Planning Act 2008 (as amended) – Section 51

Application by Gate Burton Energy Park Ltd for an Order Granting Development Consent for the Gate Burton Energy Park.

Advice following issue of decision to accept the application for examination

Drawn	Checked	Approved	Date
CG	SM	BW	JAN 2023
GH Project Number	Scale at A1		
144625.001	1:2,500		
Drawing Number	Revision		
GH-144625001-LP-4	1.0

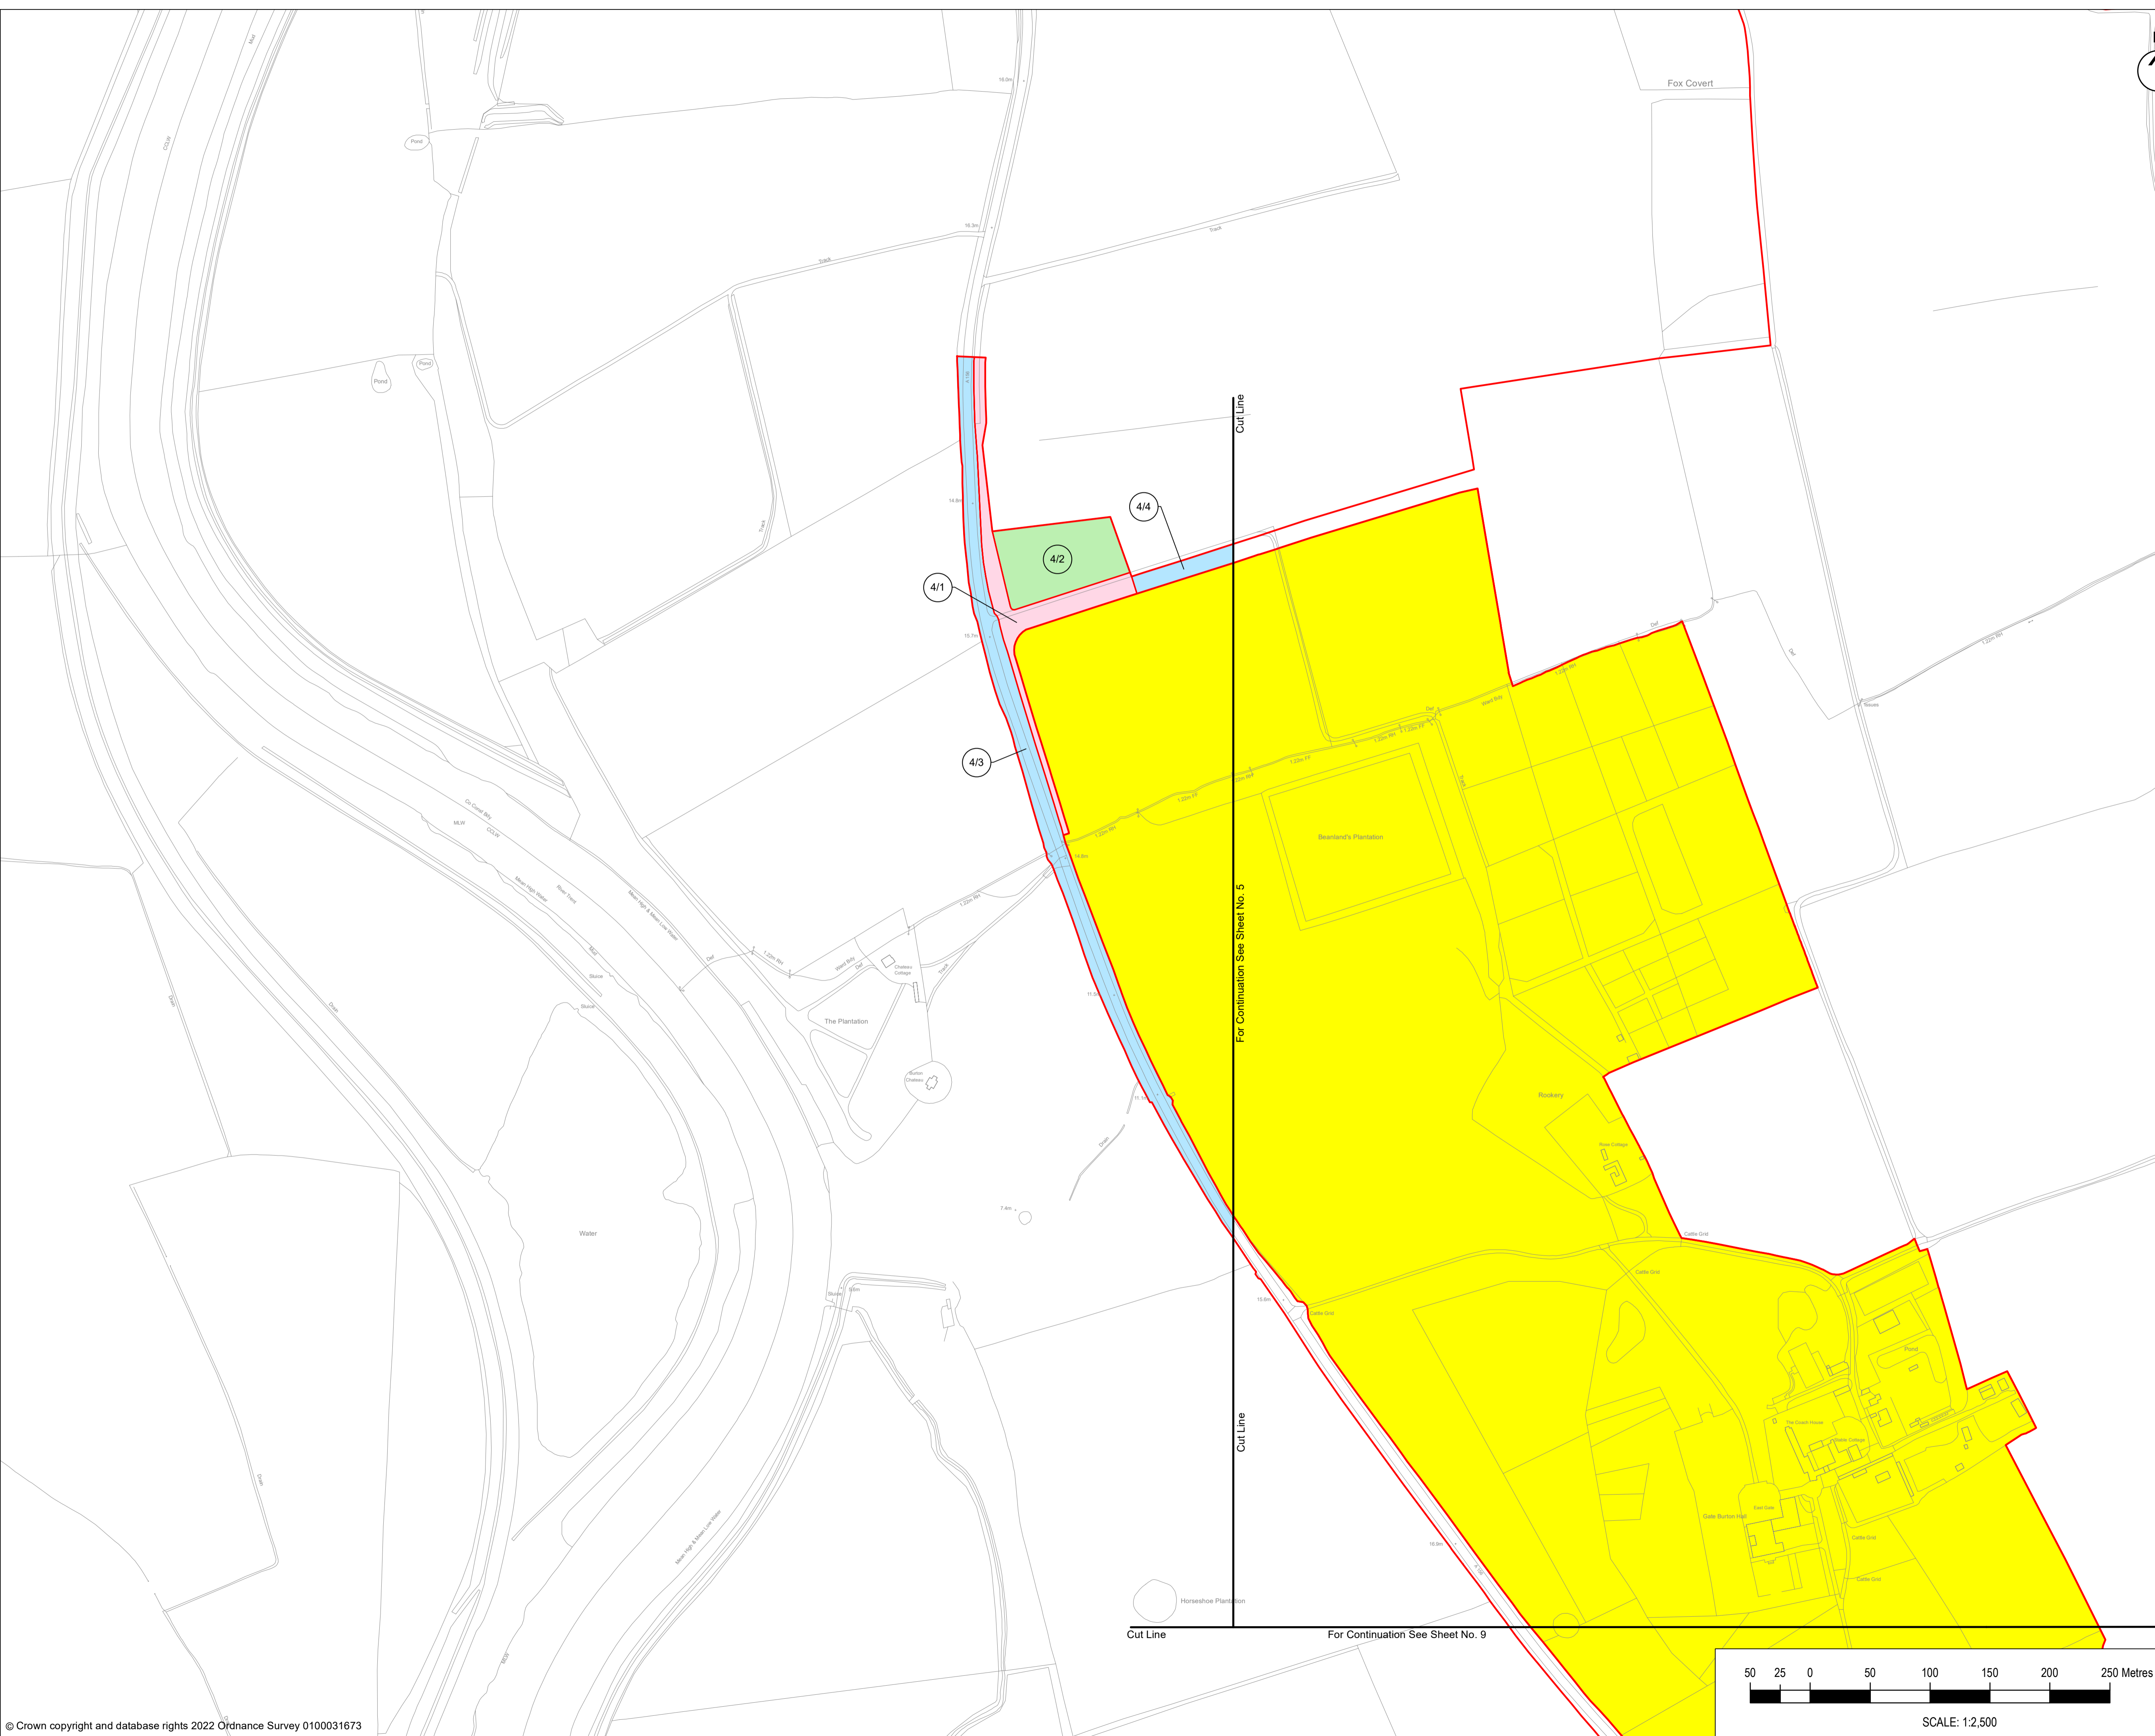
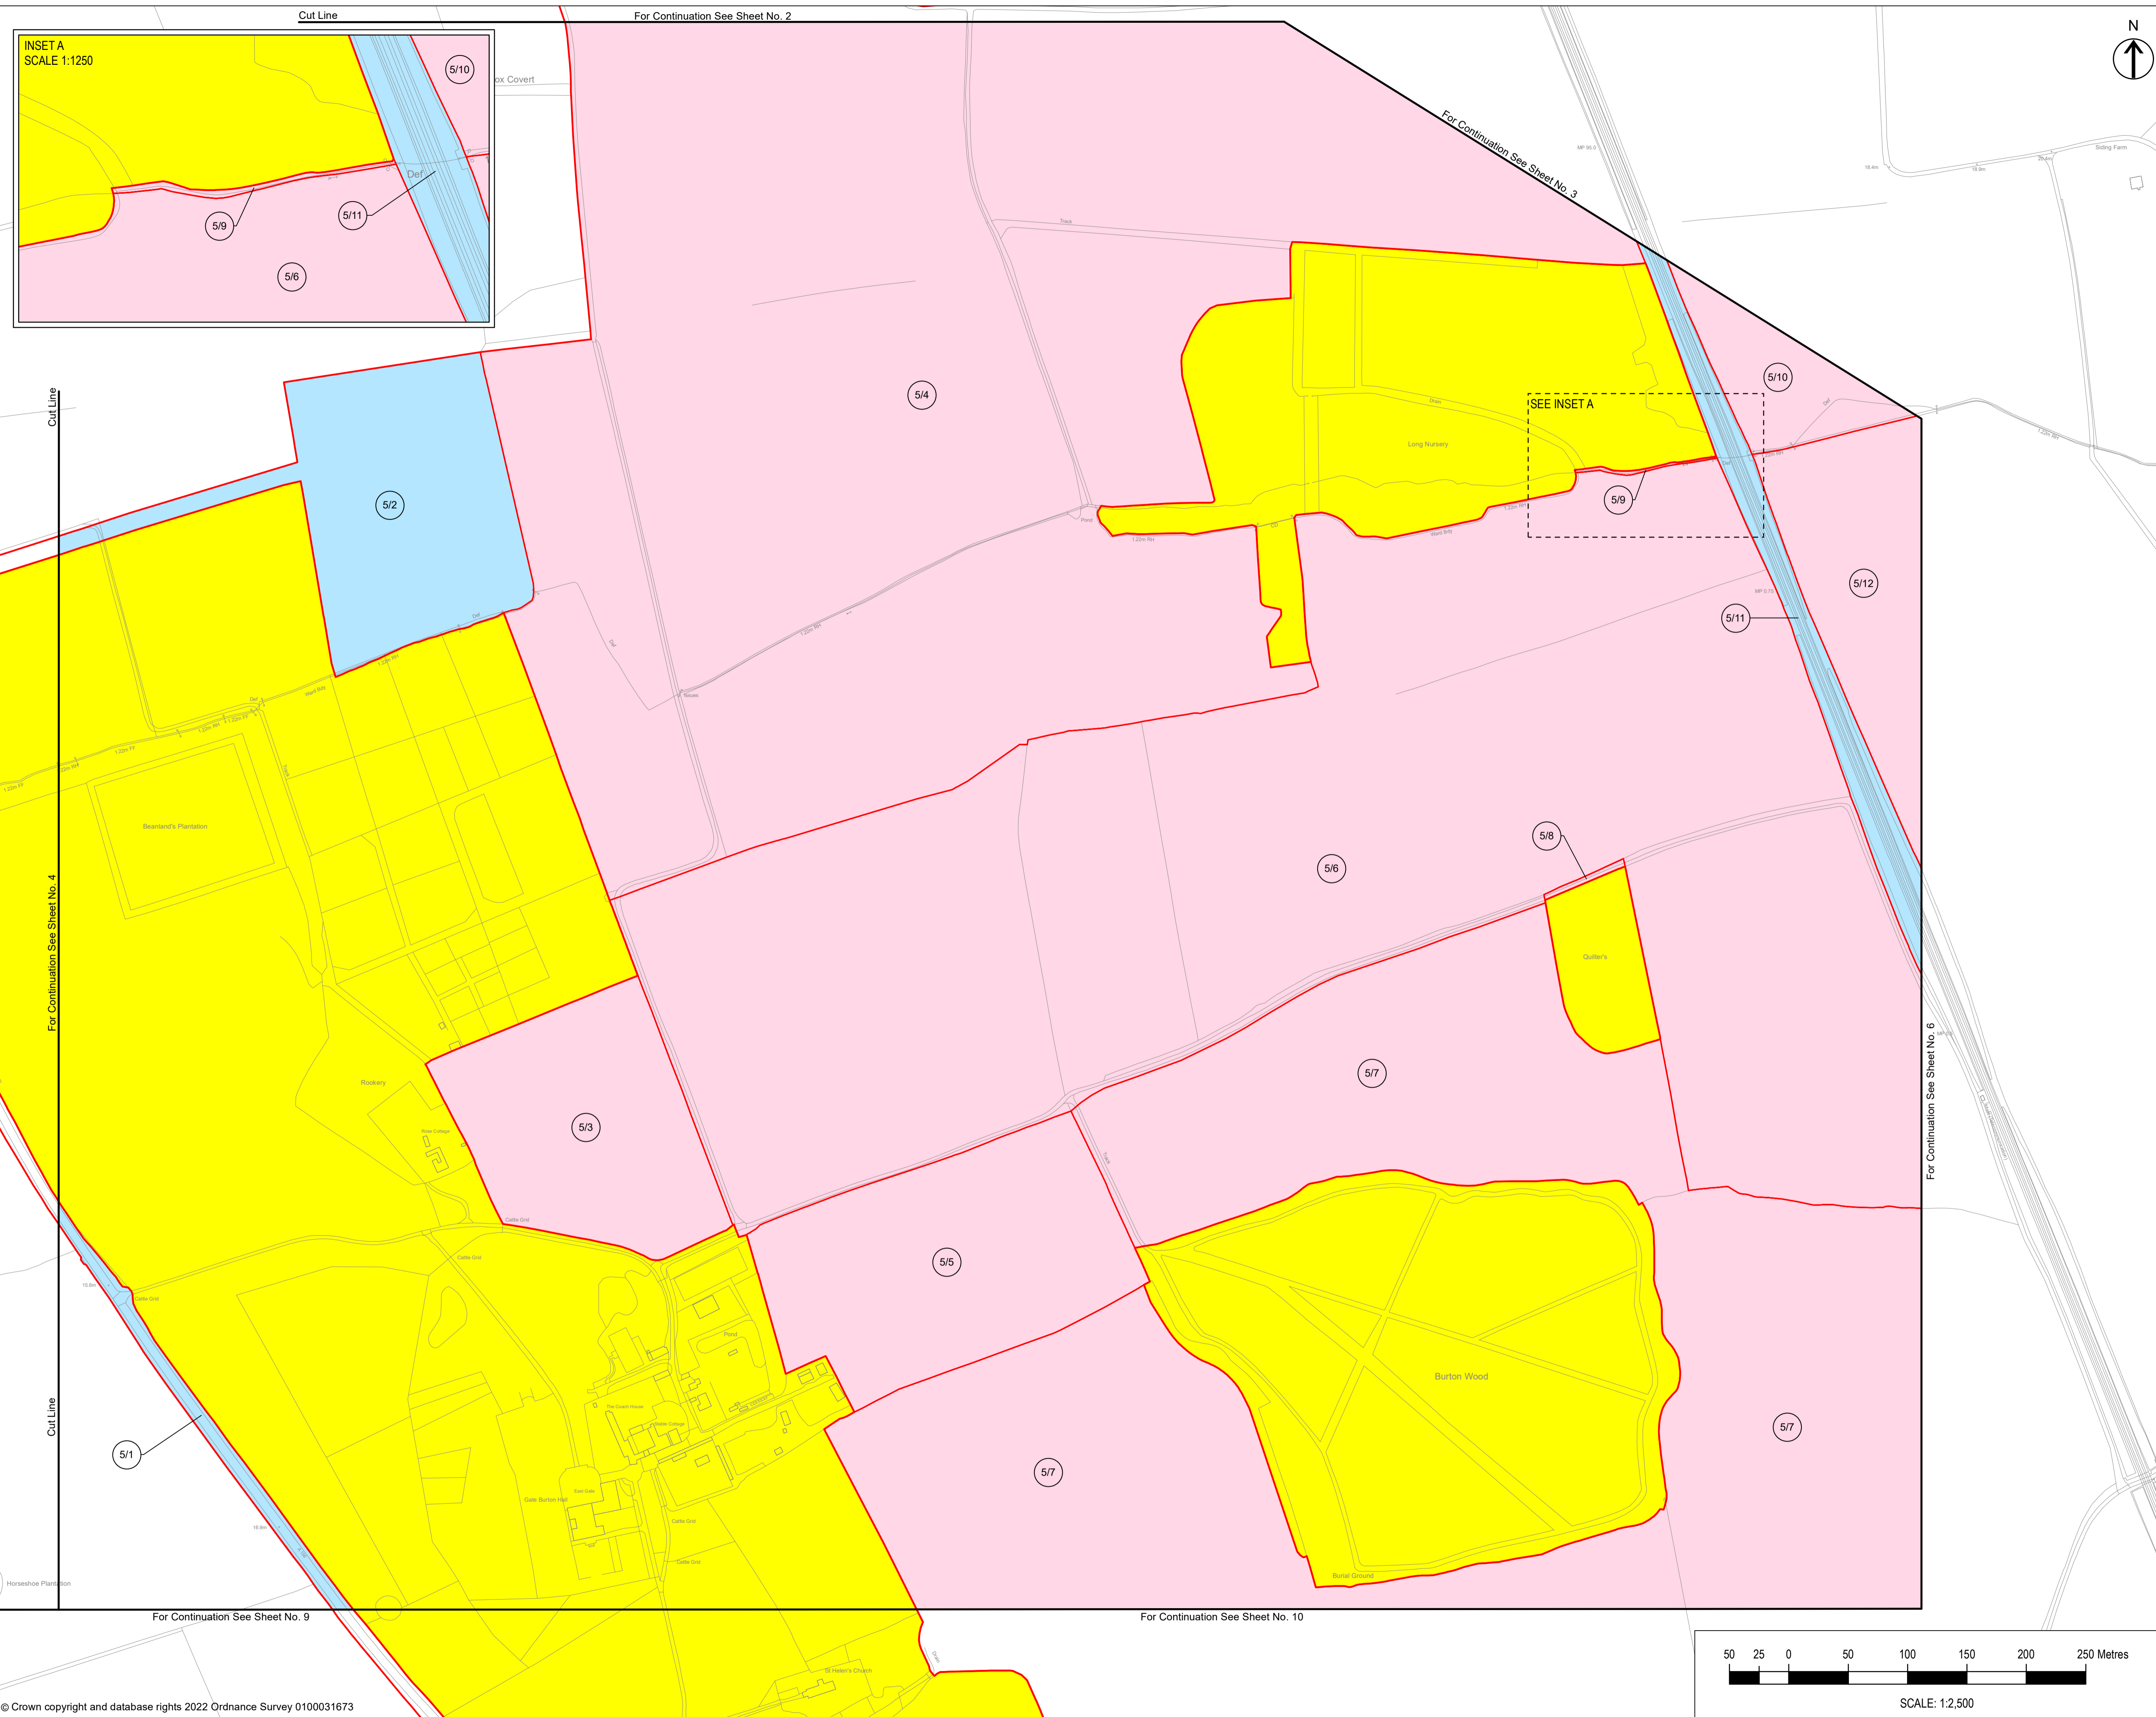
The Applicant is advised to undertake a cross-check of the Land Plans with the descriptions used in the BoR, to ensure clear and consistent read across both documents. Where geographical identifiers, such as road names and settlements, have been used in the BoR to help locate plot(s) on the Land Plan(s), these identifiers should be included on the relevant plan.

A consistency check of the colouring of the plots should be conducted, as well as labelling of inserts on plans, the Applicant should review all Legends on the Land Plans to ensure no typographical errors, as per the errors highlighted in Box 30 of the acceptance checklist.
